Rezoning Transportation Analysis

Petition Number: #2022-096

| Date | Description |
|----------|--------------------|
| 11-28-22 | First Review (TM) |
| 7-28-23 | Third Review (ME) |

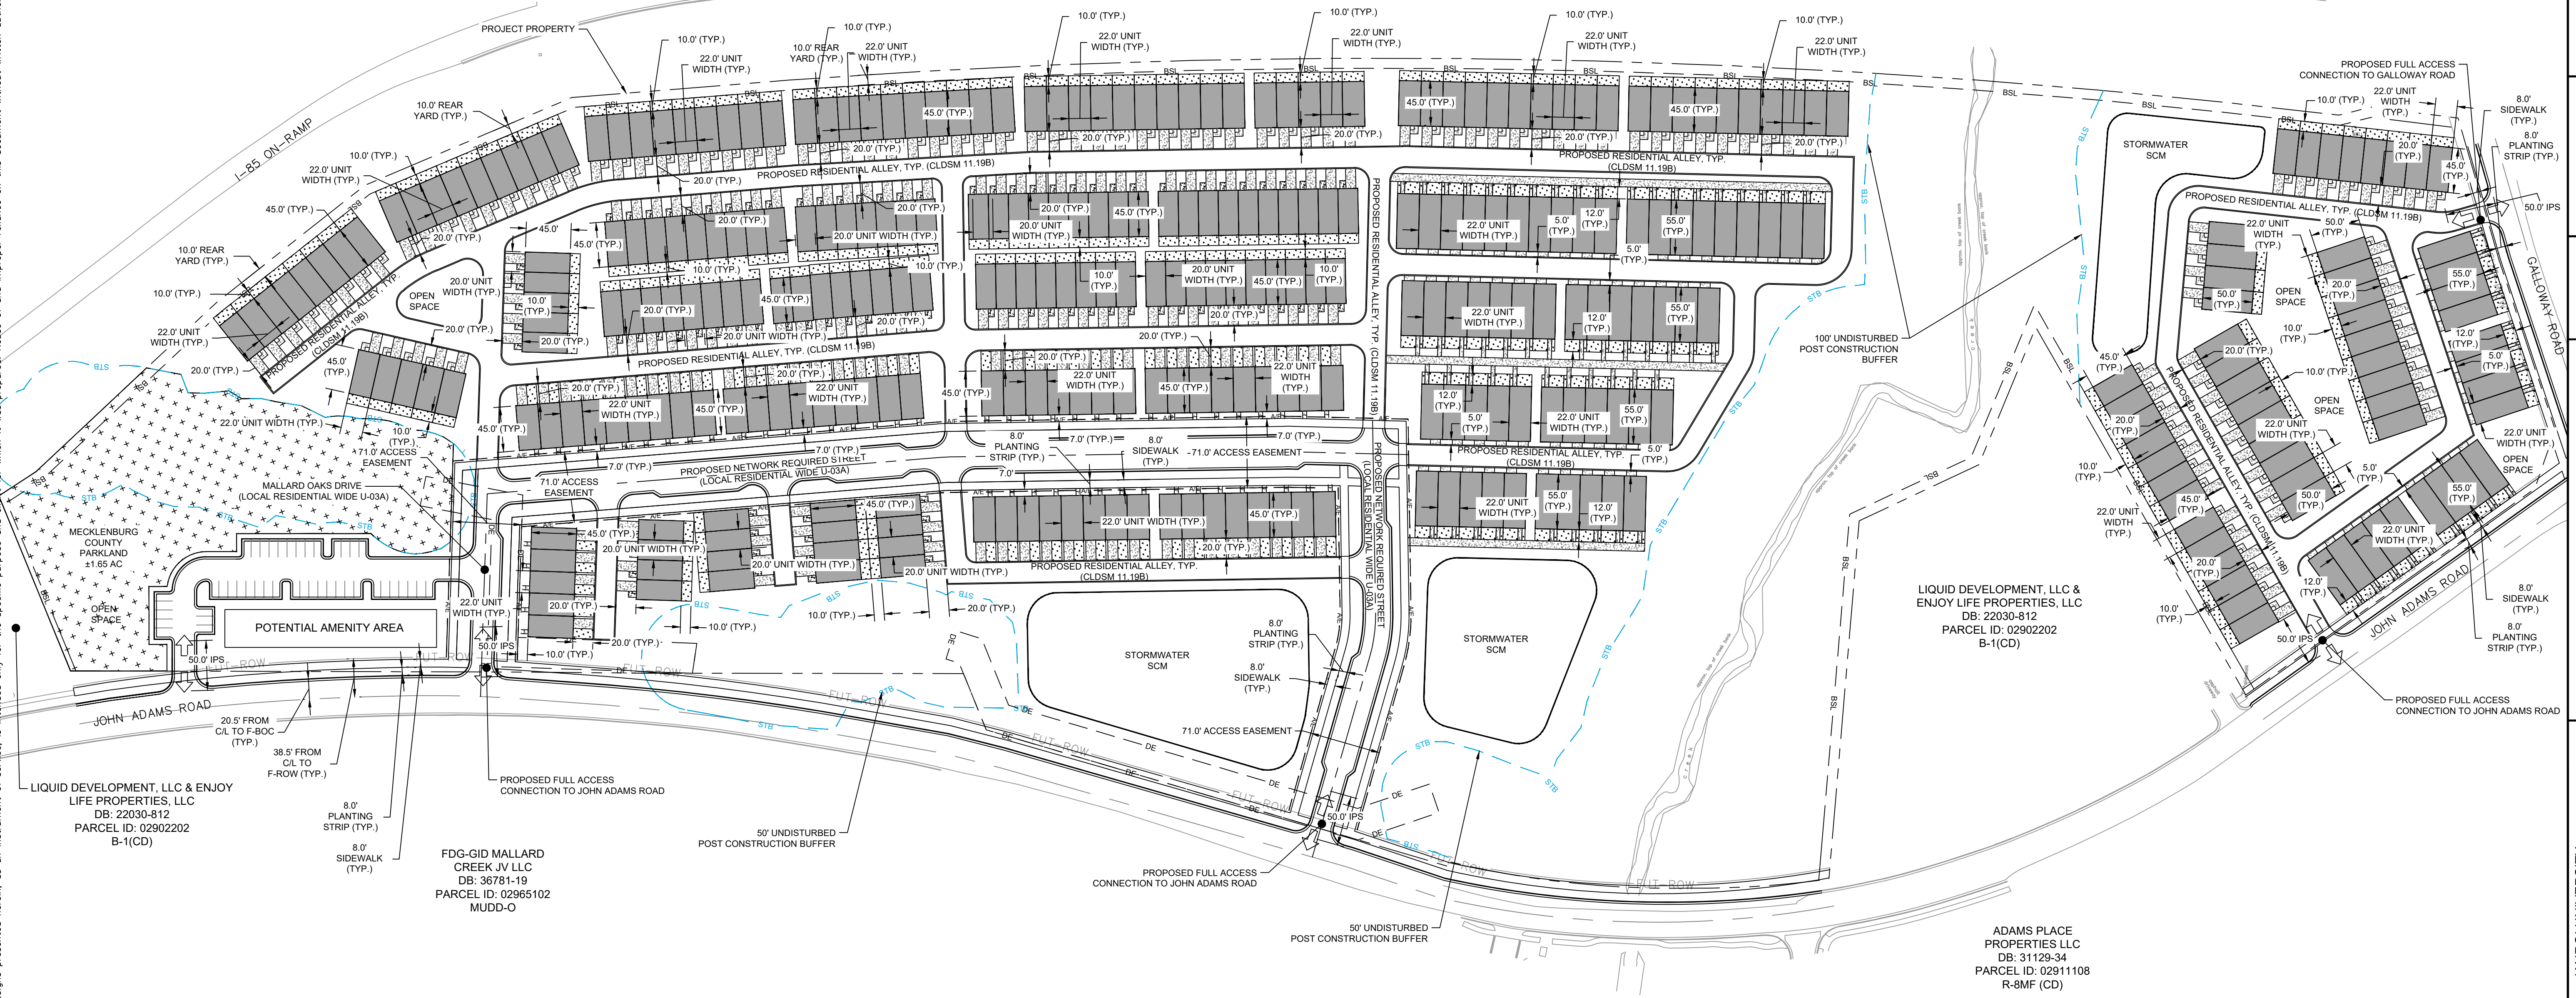
3. **New Comment 07.28.2023:** Due to the increase in unit count and trip generation for the site along with additional development in the direct vicinity of the site, CDOT is **REQUESTING** that the development complete a Comprehensive Transportation Review (CTR) as outlined in Article 32.1 of the UDO and the Charlotte Streets Manual.
4. ~~Revise site plan and conditional note(s) to commit to dedicate 38.5 feet of right-of-way from the road centerline. The site plan shall label and dimension the right-of-way from the road centerline.~~
5. ~~Revise site plan and conditional note(s) to commit to construct an 8-foot planting strip, and 8-foot sidewalk on John Adams Road and Galloway Road per Chapter 19. The site plan shall label and dimension both items from the back of curb and gutter and road centerline.~~

7. Conditional note(s) revisions are needed to commit to correcting grade break issues along John Adams Road. Add conditional note to commit to this improvement along John Adams Roadway.

11. **New Comment 6.21.2023:** Label and dimension internal channelization (internal protected stem) and ensure that each driveway provides a minimum 50 feet. No parking shall be allowed within the minimum 50 feet of internal channelization.
